Traffic & Safety – Permits Unit

US-24G (E-X) | Peterson Rd
El Paso County

RE: Hillpointe Apartments (PPR2613)

SECONDARY ACCESS FROM PETERSON ROAD

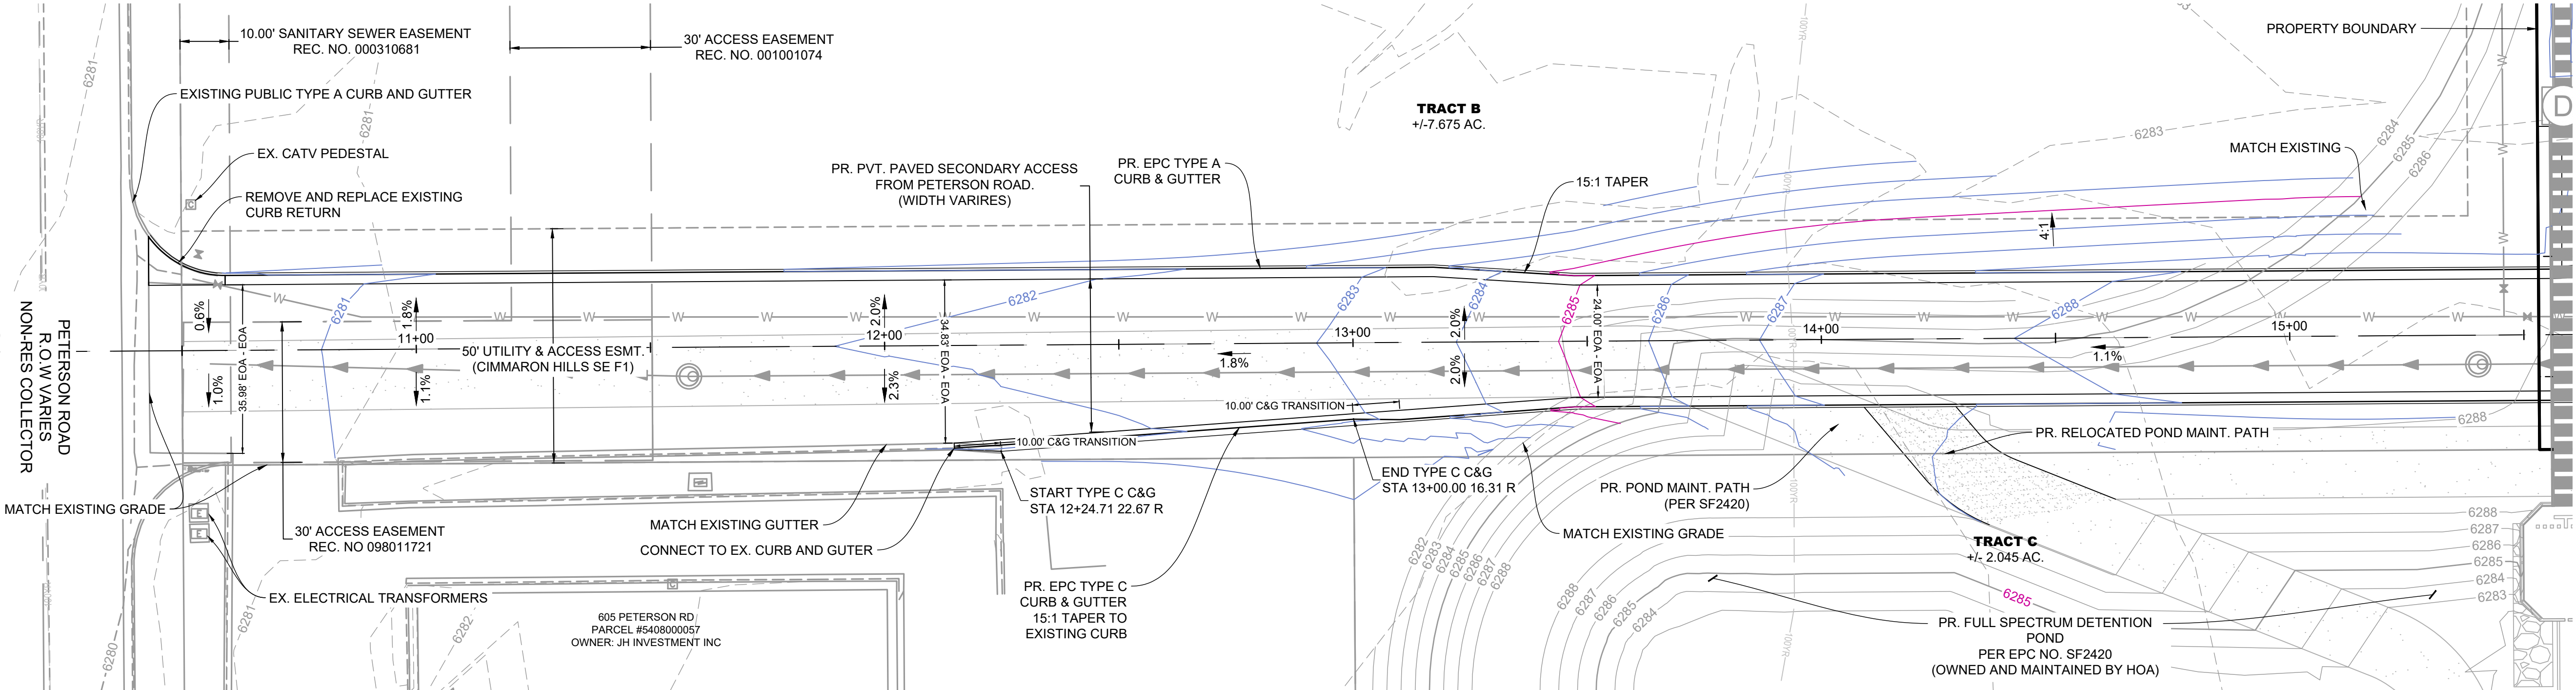
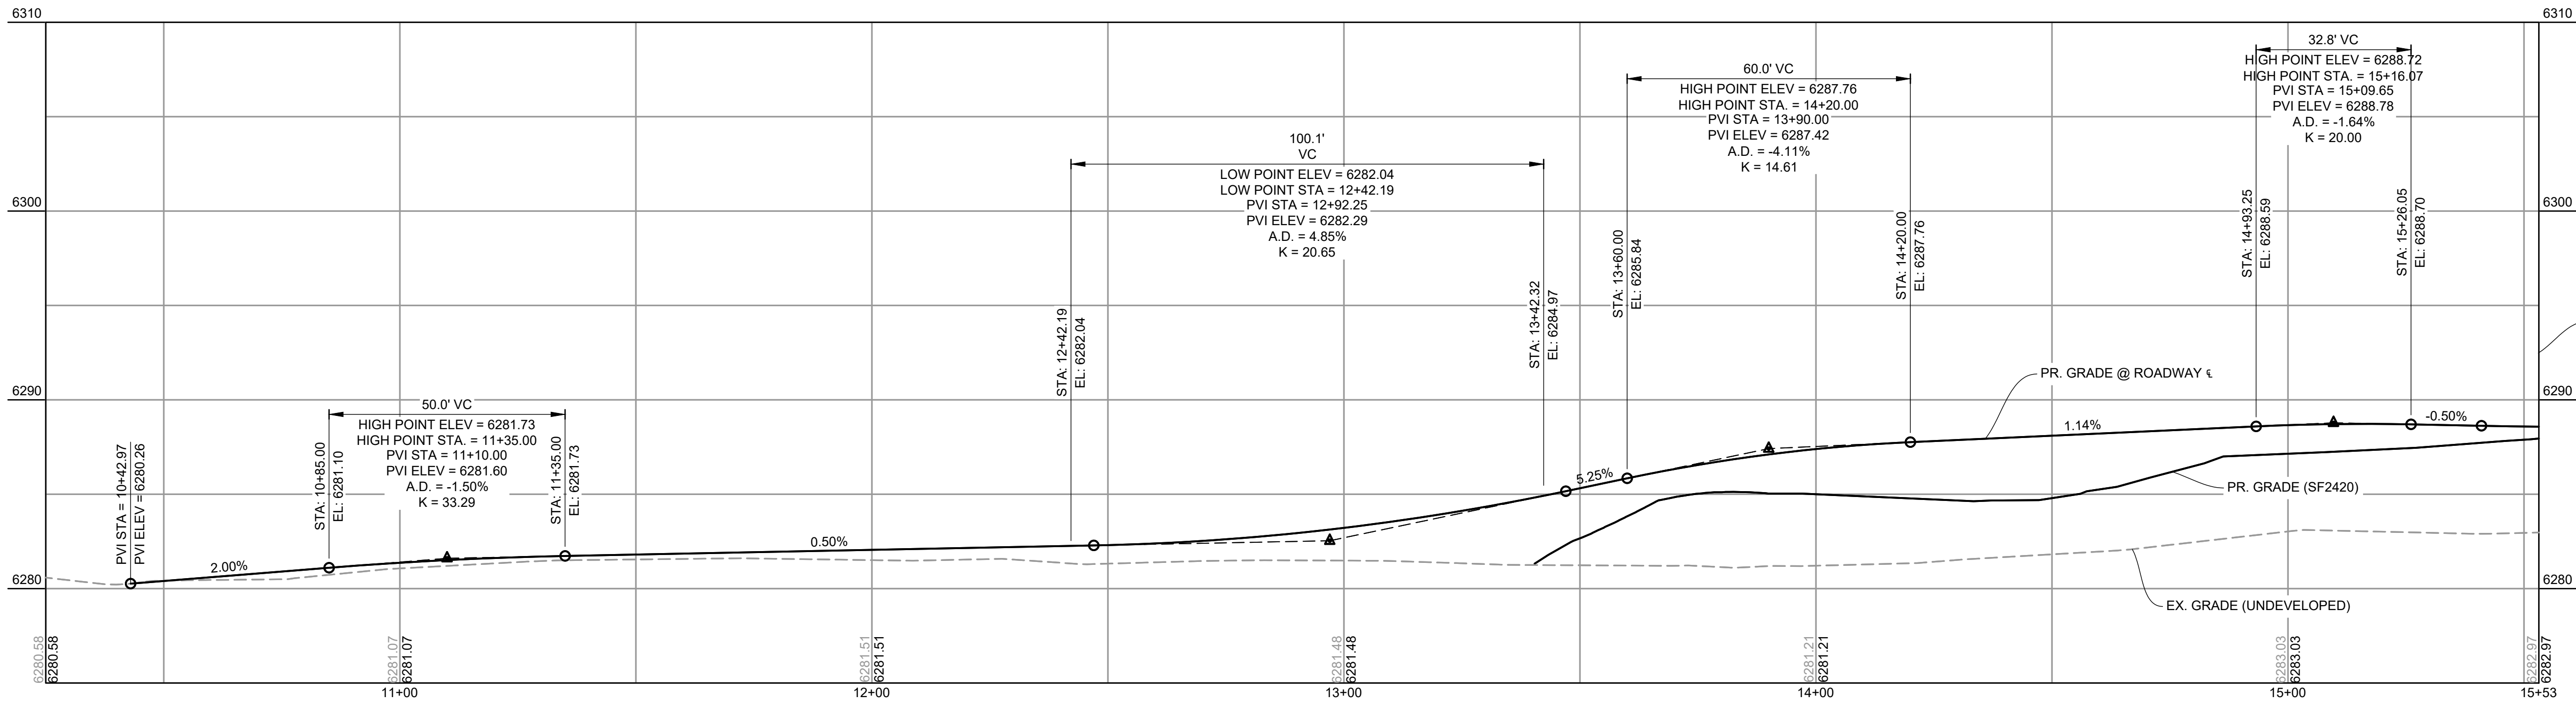
- Roundabouts are being constructed at US-24G (E Platte Avenue) and Peterson Blvd which will improve interchange operations. The existing access is ± 275 feet north of the off-ramp terminal from US-24G. The existing cross-over at Panamint Court shall be eliminated and median constructed across.

- The Traffic Impact Study for “Hillpointe Apartments at Peterson” dated September 2025, revised May 2026 states:
“Proposed access to the development is provided via one full-movement access onto the future extension of Meadowbrook Parkway (referred to as Site Access). This access is anticipated to be shared with the future adjacent Cimarron Hills development.
Additionally, it is noted that the existing intersection of Peterson Road with Panamint Court will be converted to a right-in/right-out intersection and serve as an emergency-only access for the proposed development.”

- o The median closure to convert the existing access to right-in/right out will be a condition of the permit.
 - o A CDOT Access Permit Application has been received for this development but is currently on hold pending receipt of multiple documents to complete the submittal.
